Re: Objection to MP08_0244 MOD 1 Modification Request for Mixed Used Development at 23-37 Lindfield Avenue and 11 Havilah Lane, Lindfield

As a resident of Lindfield, I/we wish to lodge an objection against the proposed Modification of the subject development based on the following grounds:

3 SHADOW DIAGRAM - 21stDEC_3PM
5003 SCALE1 : 650

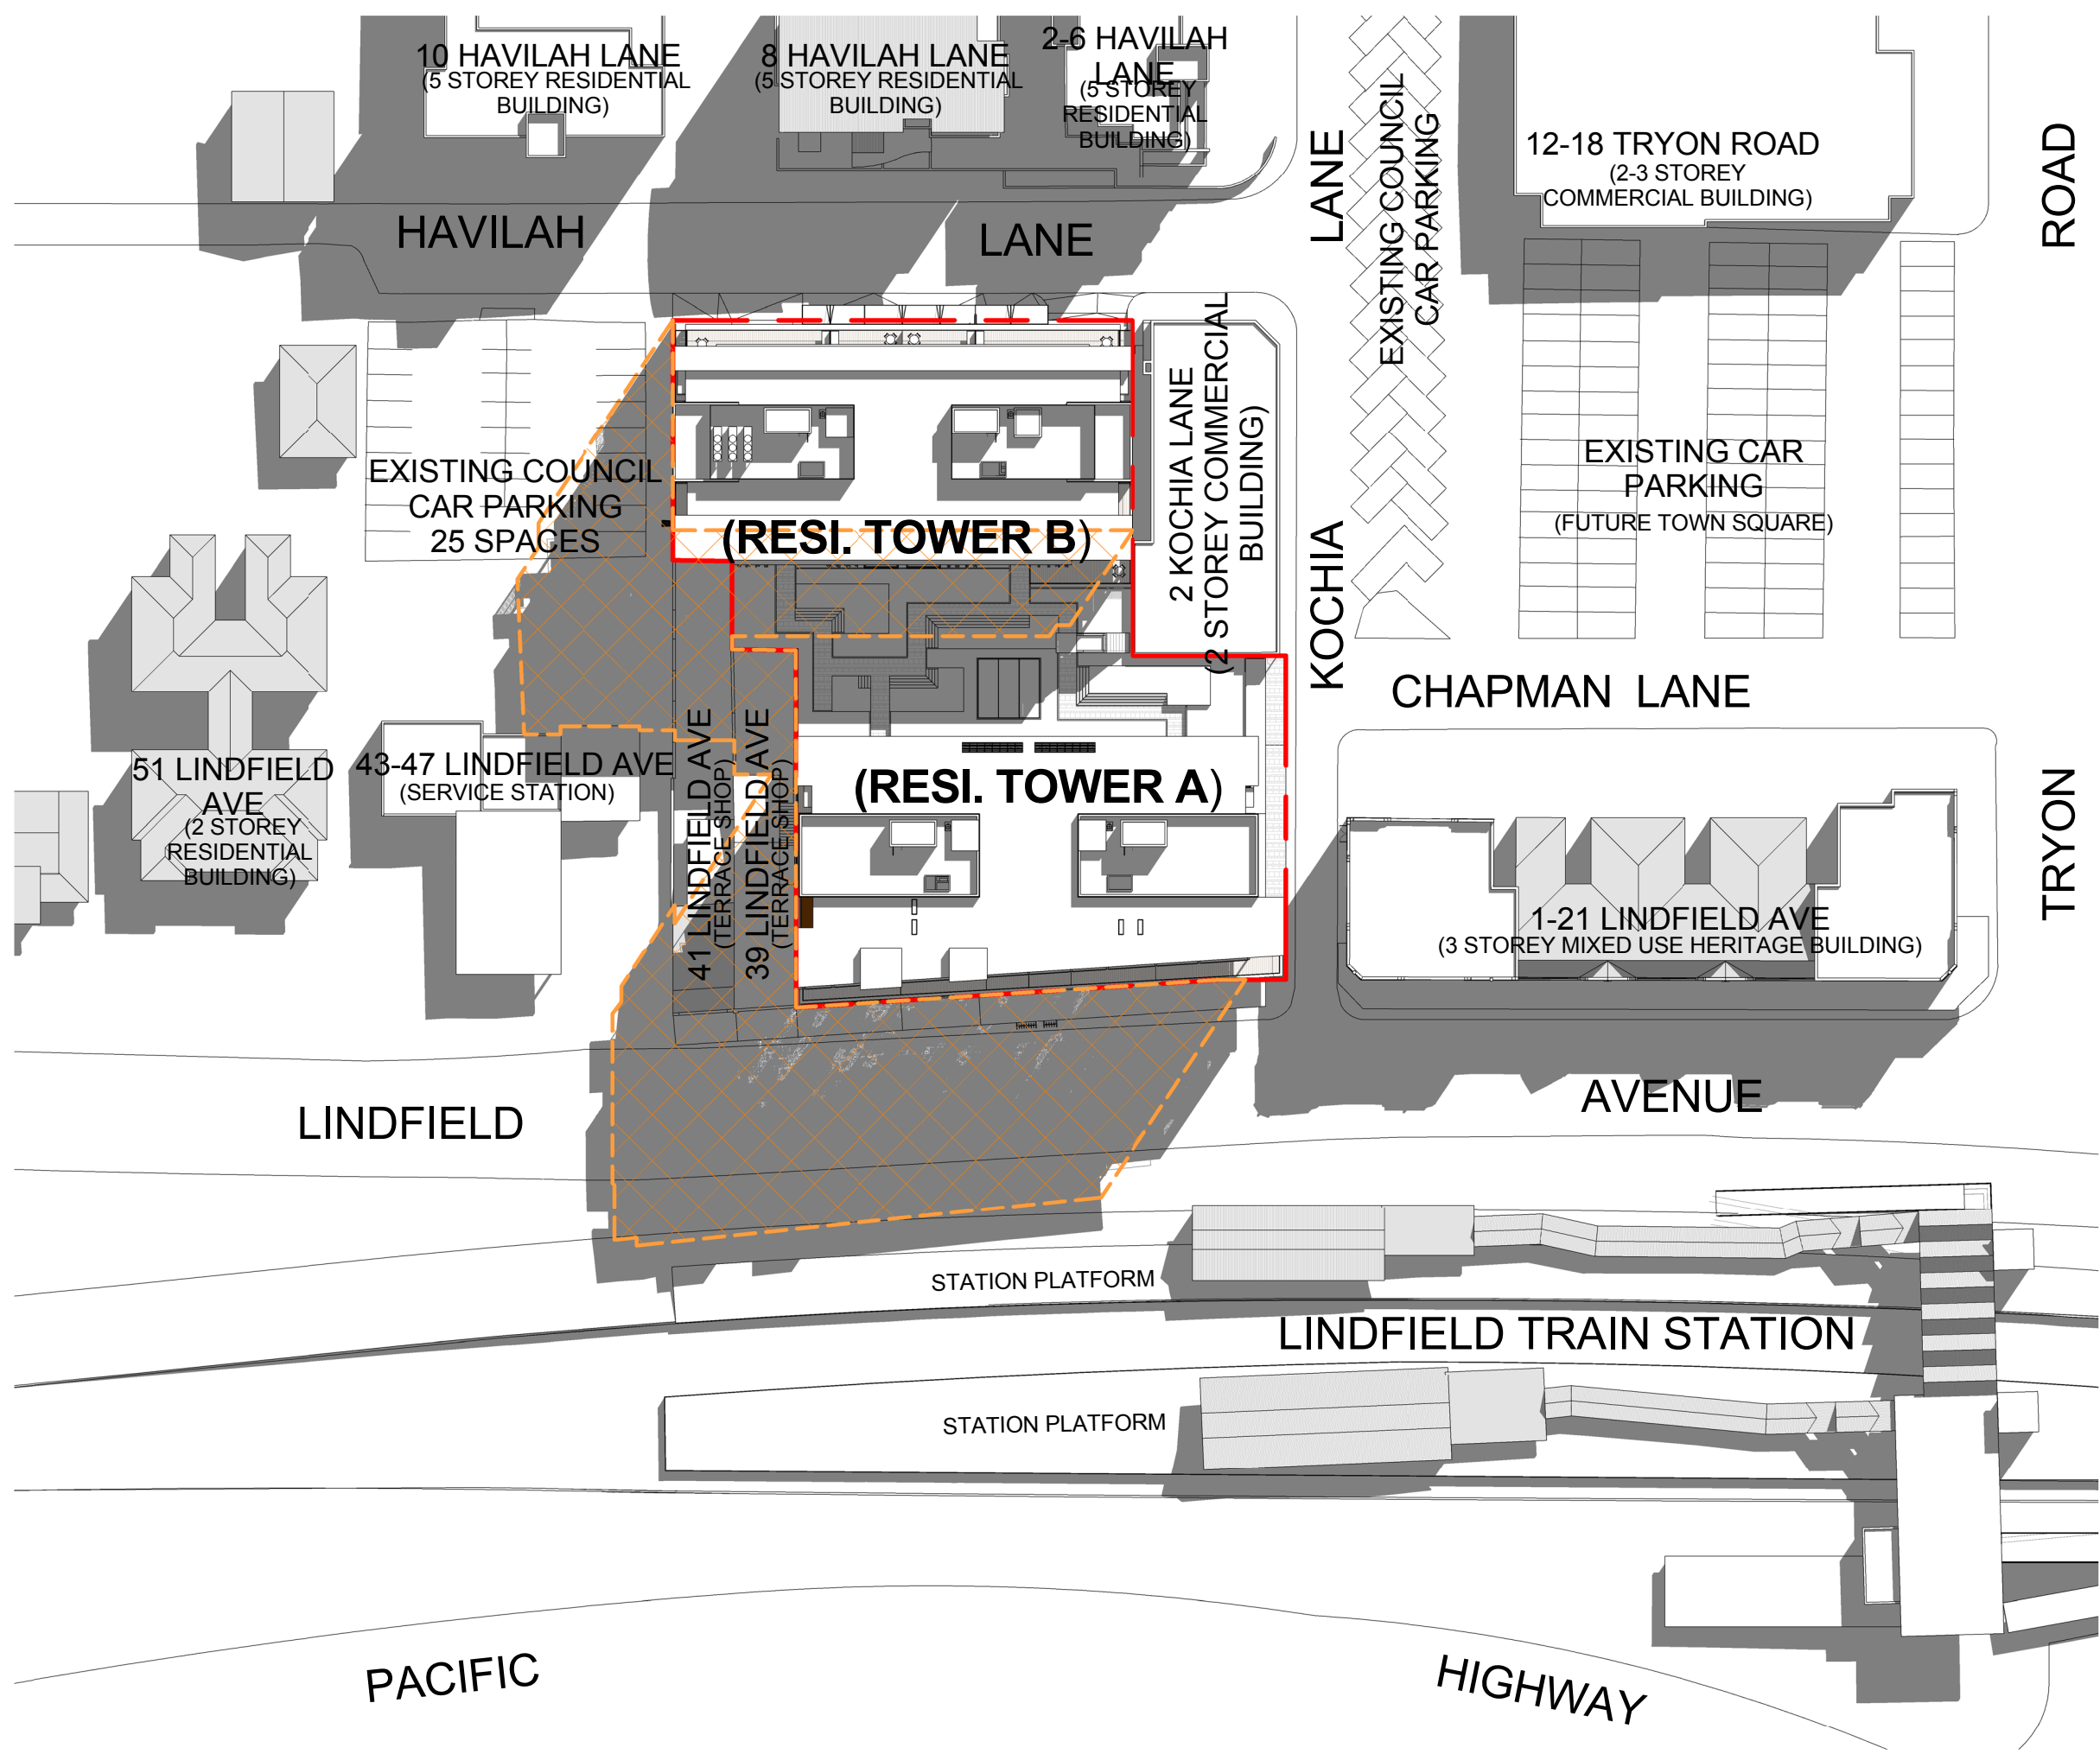
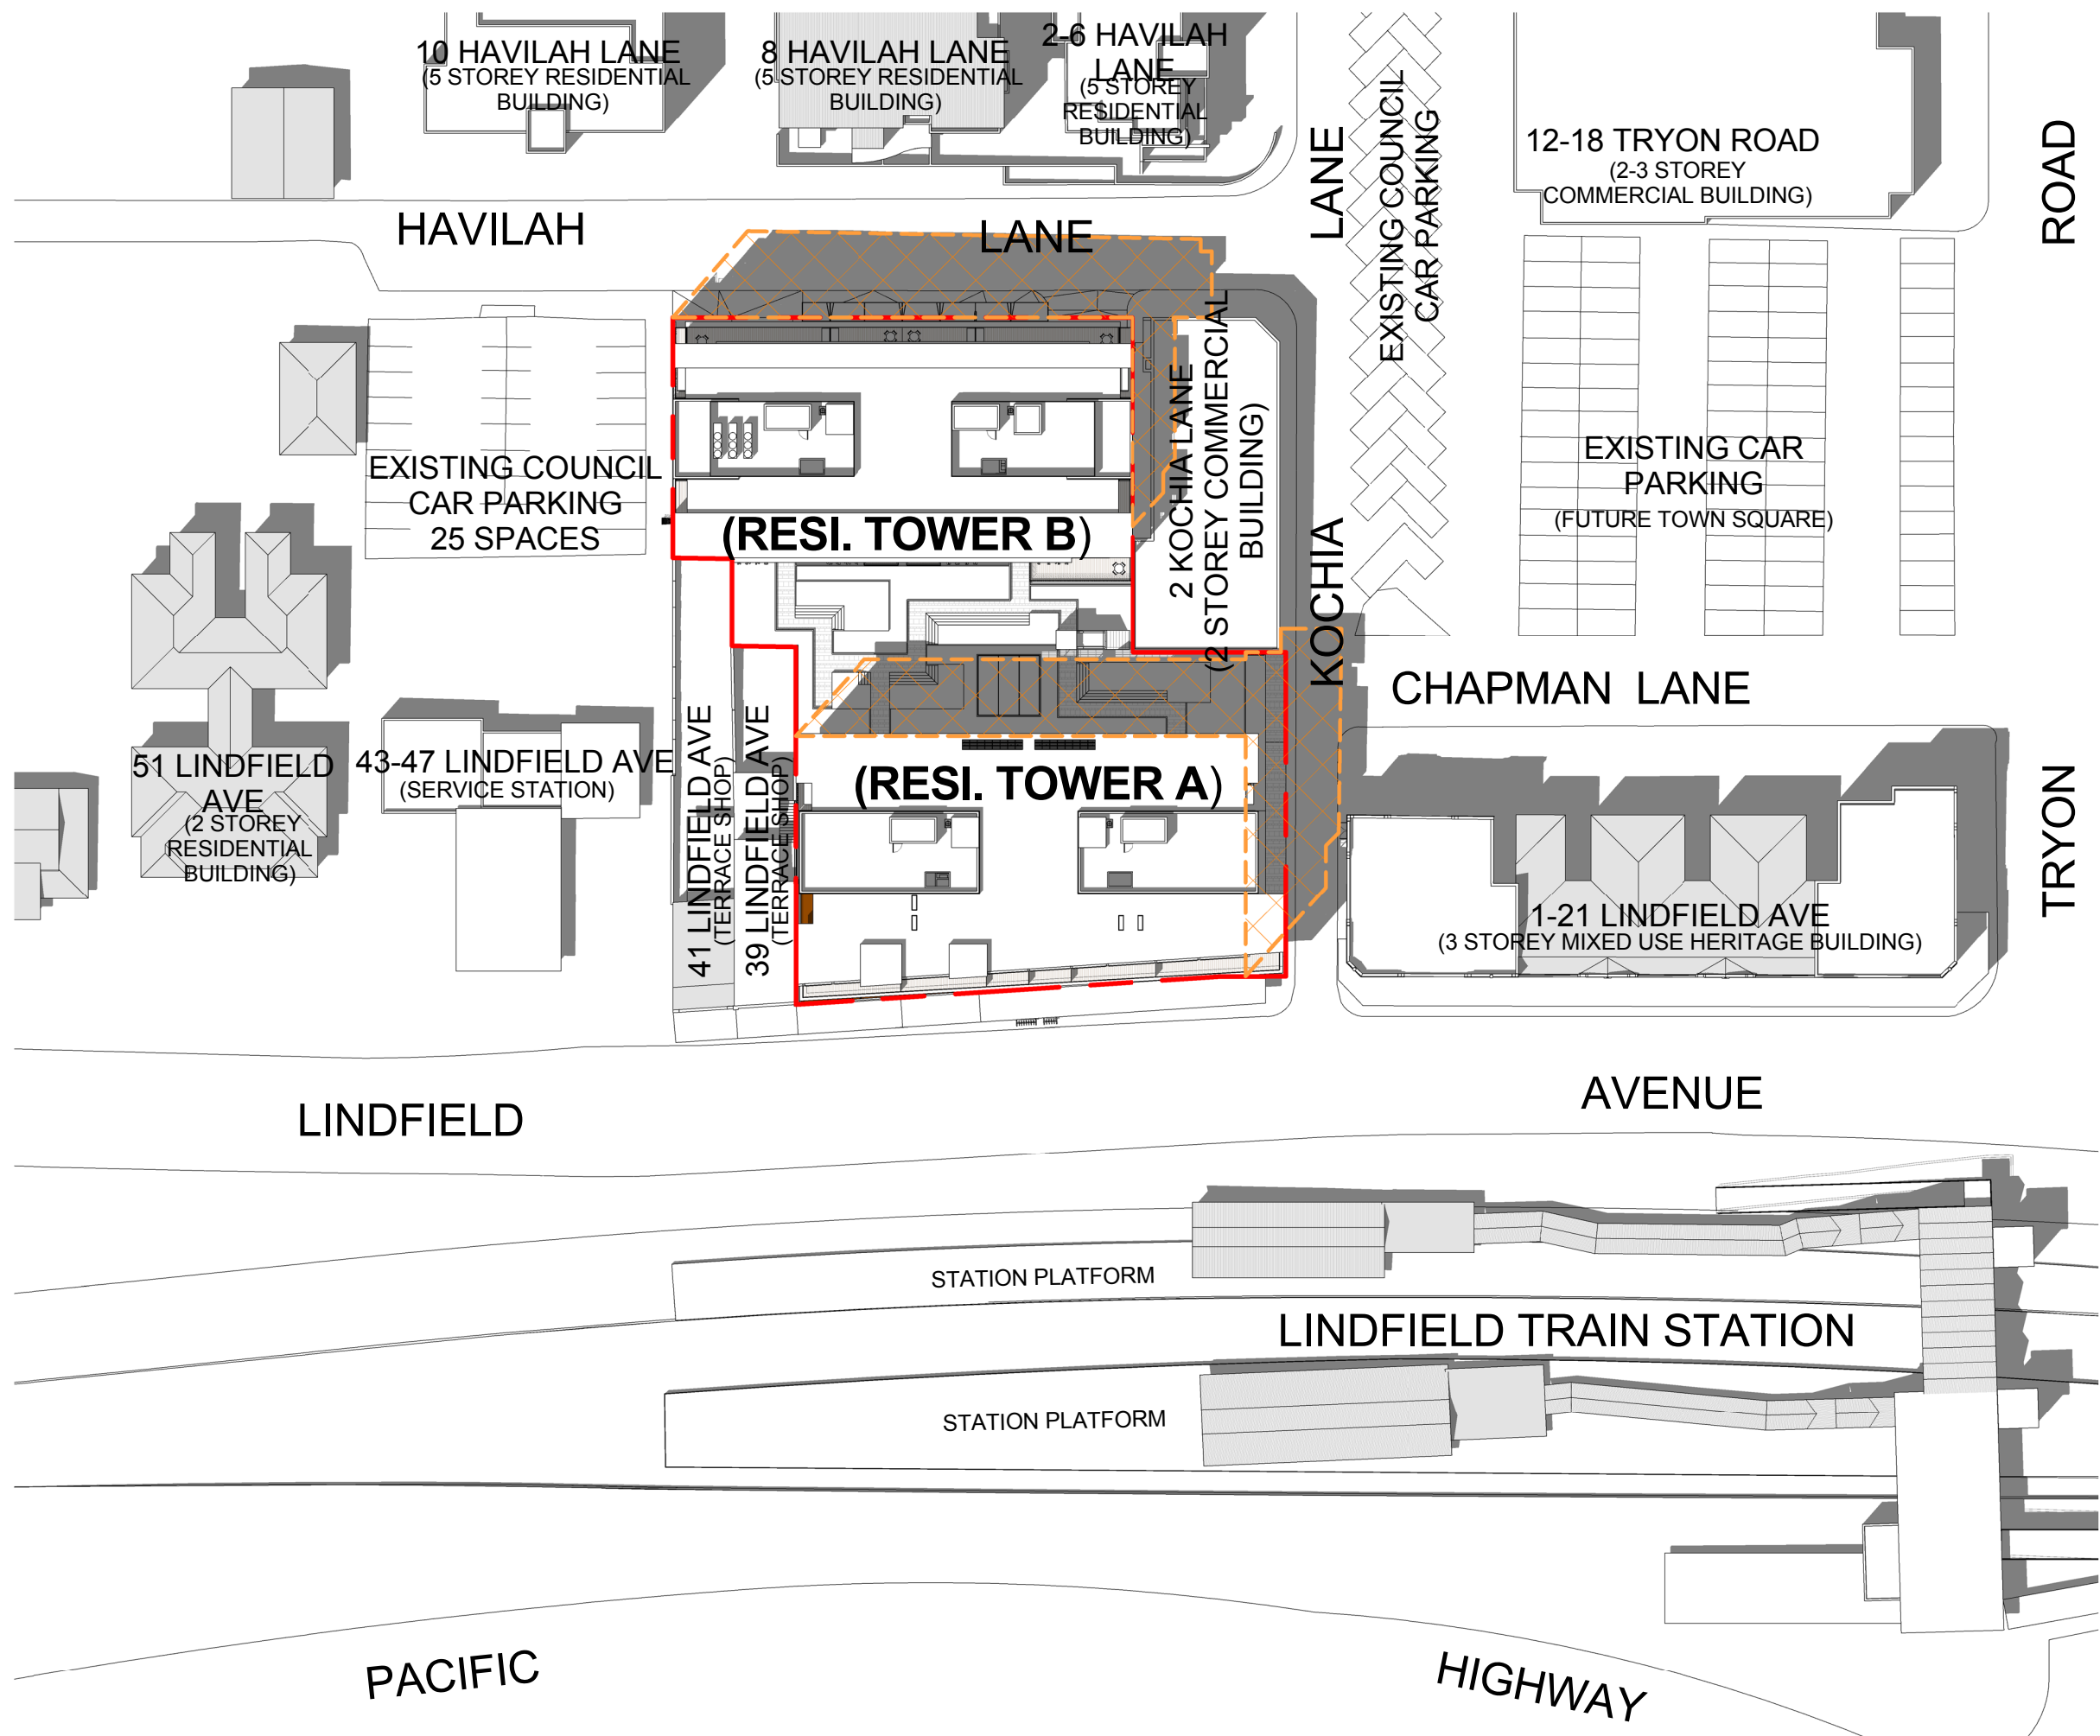
- The additional storeys create additional shadowing: particularly after 3pm for residents in the Havilah Lane apartments, and for all commuters on the city bound Lindfield rail platform, instead of 50% of the year, it will now be 75% of the year in the mornings.
